**KIRKLEES COUNCIL
TOWN AND COUNTRY PLANNING ACT 1990
HIGHWAYS DEVELOPMENT MANAGEMENT**

PLANNING REF 2017/62/90989/W0/FT
CATEGORY Minor

PROPOSAL ERECTION OF 5 DWELLINGS

LOCATION HI PYLON WORKS
SLADES ROAD
BOLSTER MOOR
HUDDERSFIELD
HD7 4JS

DRAWING TITLE
 SITE AND STREETSCAPE
 AS PROPOSED

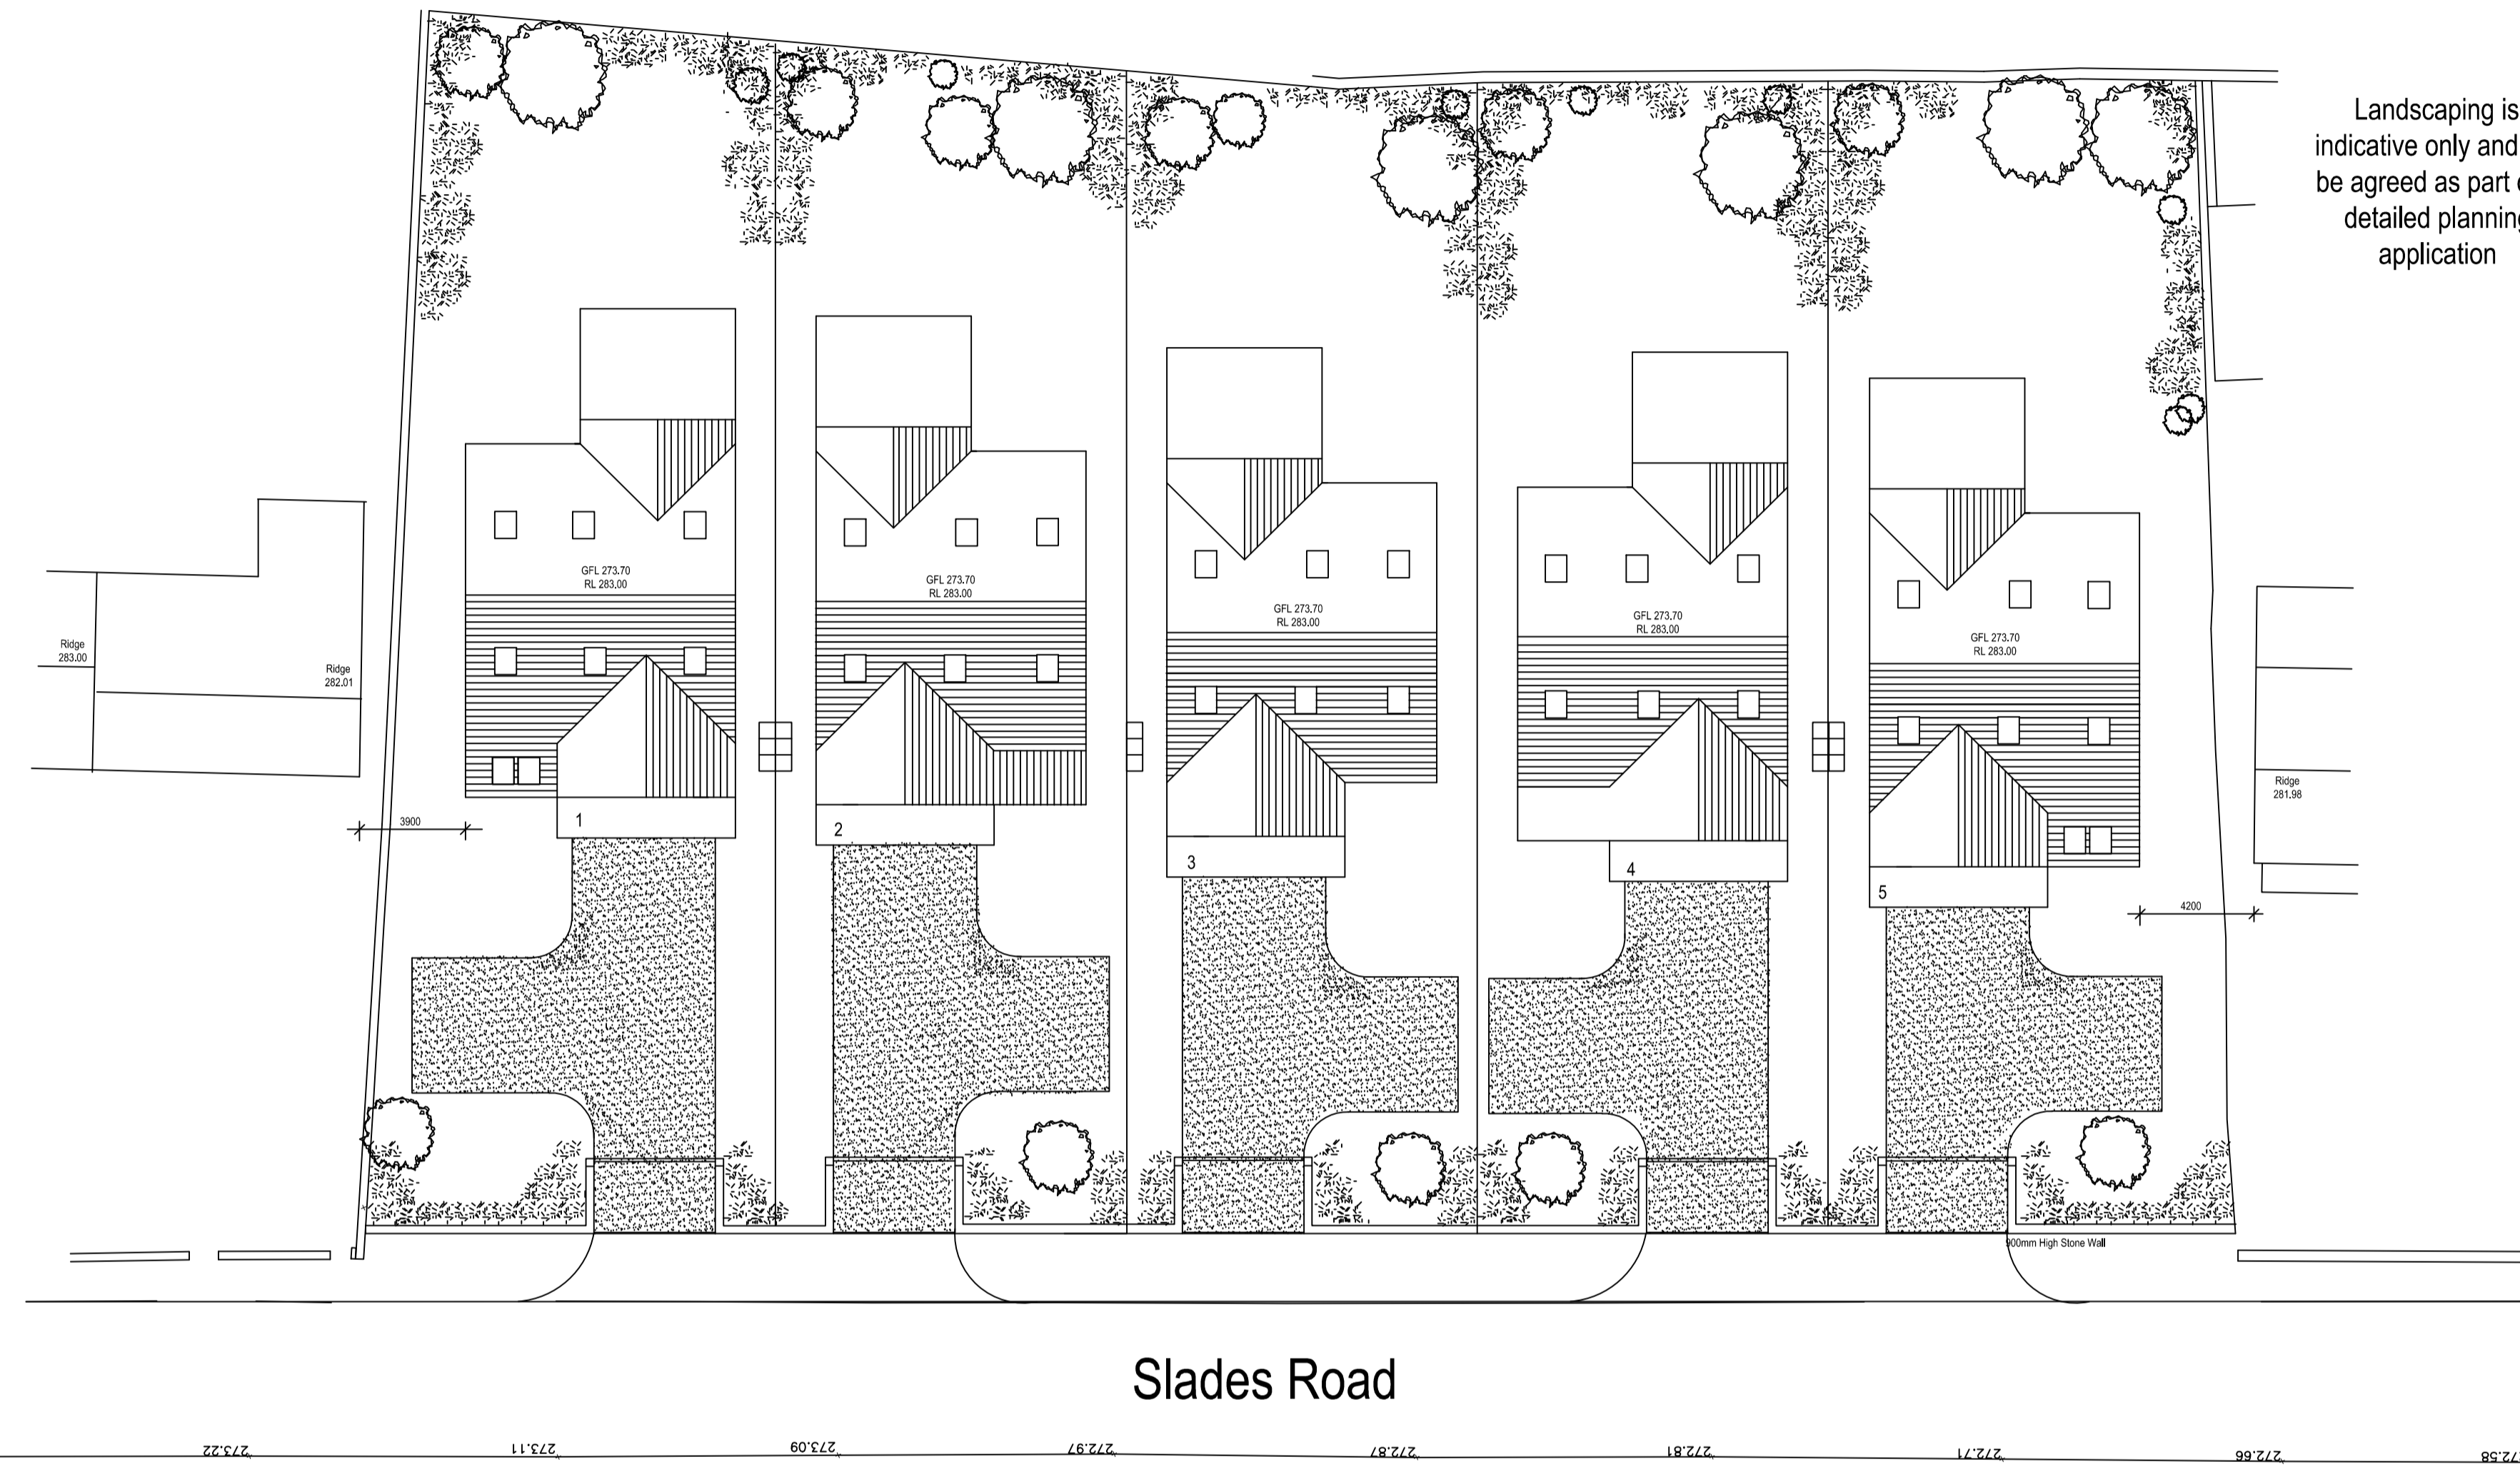
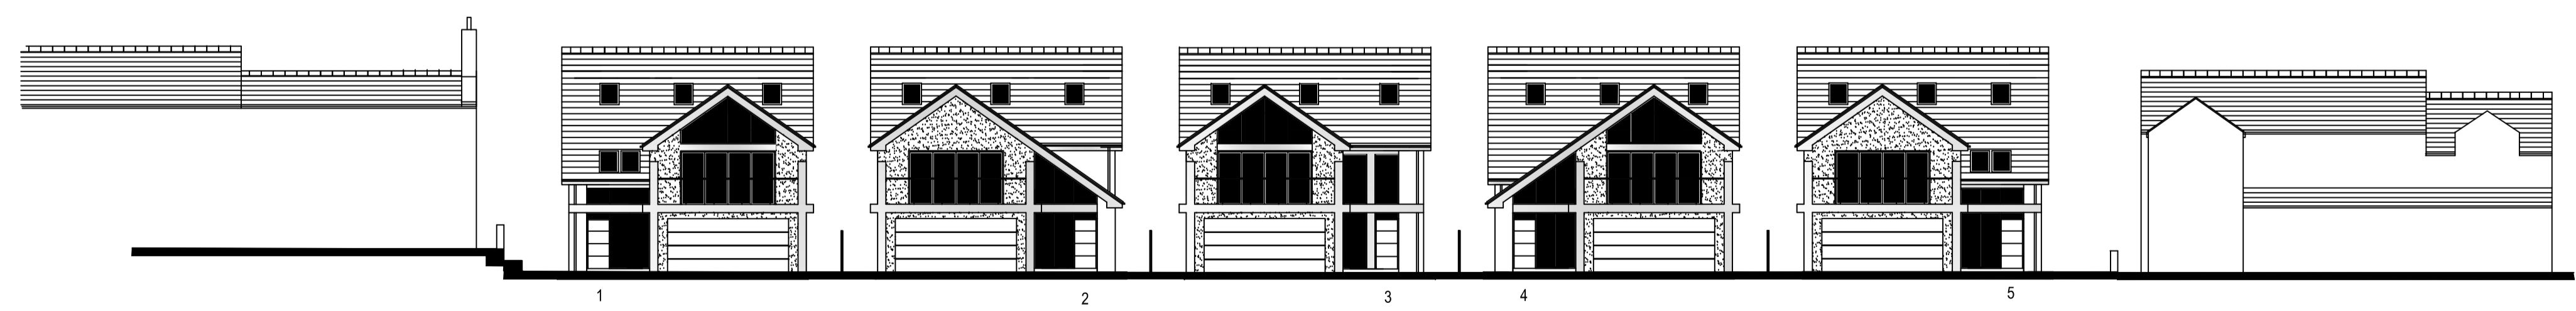
The scheme now provides direct dwelling access to Slades Road for each of the 5 dwellings. This is acceptable in principle, however the submitted plans show that dwelling number 3 is not served by a dropped crossing. An updated plan illustrating the proposed dropped crossings is required.

1) Development shall not commence until a scheme detailing the layout, construction and specification of the highway works at the individual dwelling accesses with Slades Road; (and all associated highway works) has been submitted to and approved in writing by the Local Planning Authority. The development shall not be brought into use until all the works under the approved scheme have been carried out and completed in accordance with the approved scheme.
